Our ref: HA/2009/108573/01-L01

Date: 15 December 2009

**CONVERSION OF GROUND FLOOR SHOP PREMISES AND FIRST
FLOOR FLAT OVER INTO SELF CONTAINED TERRACE TOWN HOUSE**

12 BAYFORD ROAD LITTLEHAMPTON

GROUND FLOOR PLAN

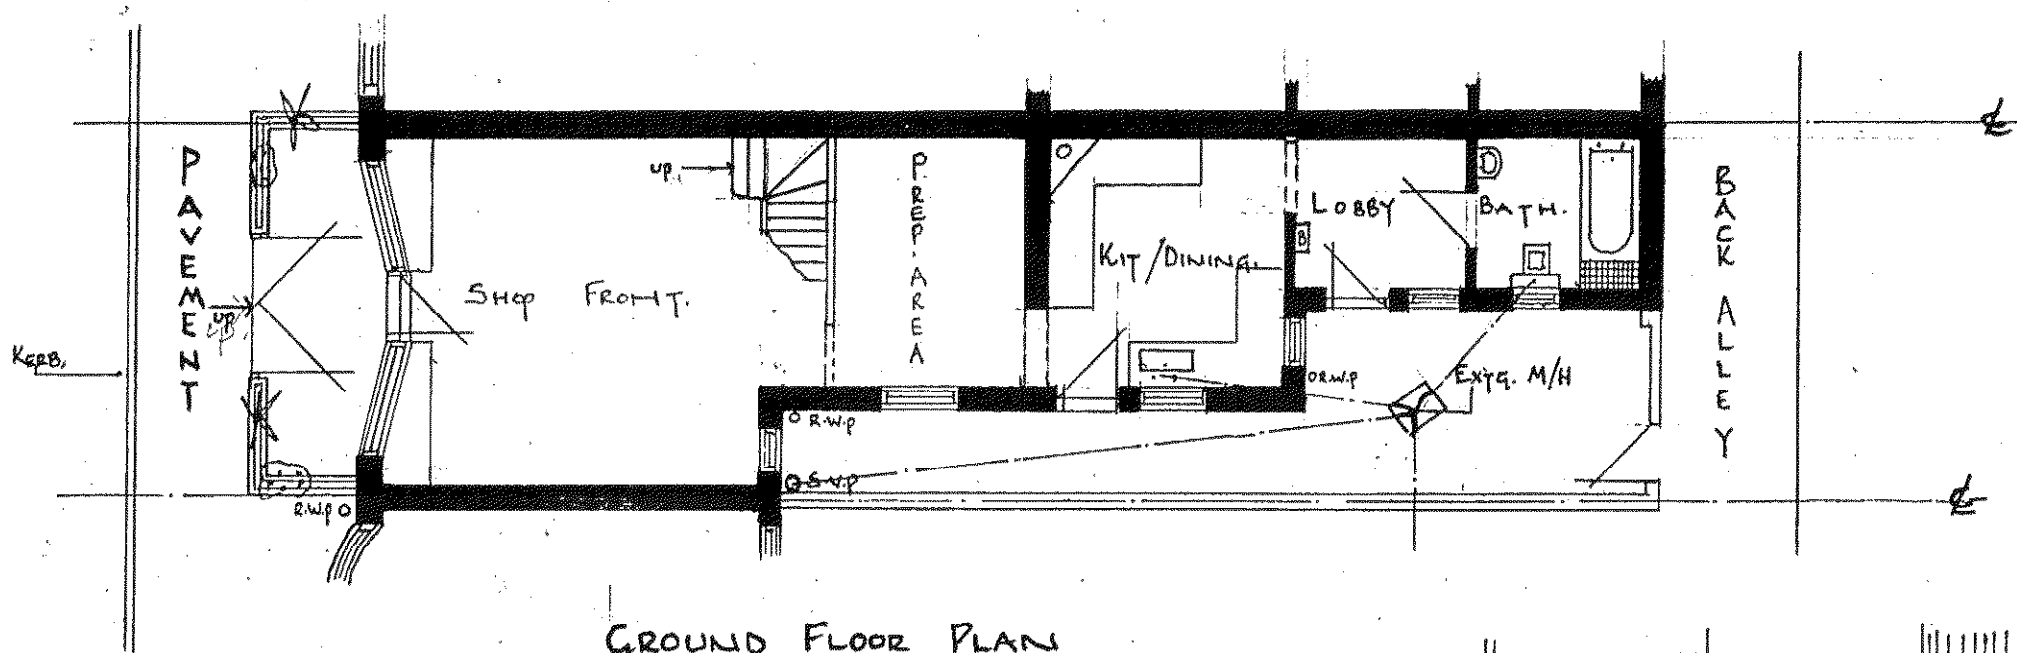
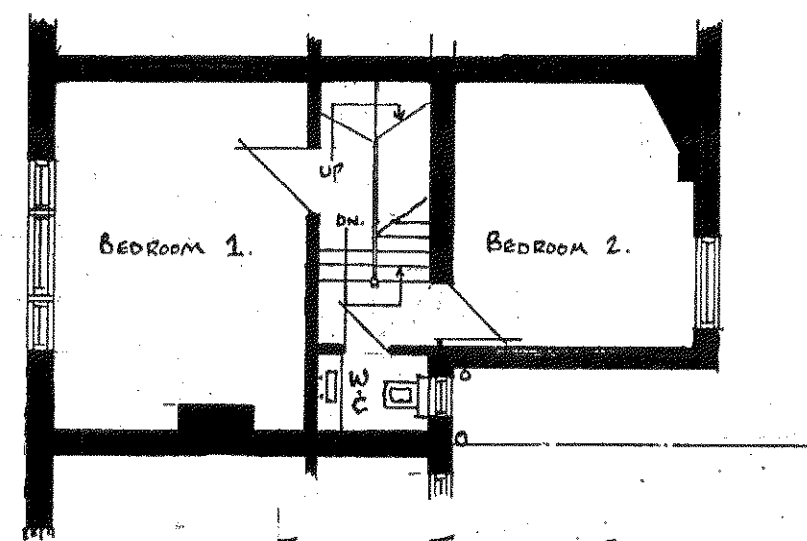
The submitted drawings show that there are existing habitable rooms at present on the ground floor of this property. Therefore we do not consider that there is a significant increase in vulnerability (in line with table D2 of PPS 25) and do not wish to object to this proposal on flood risk grounds.
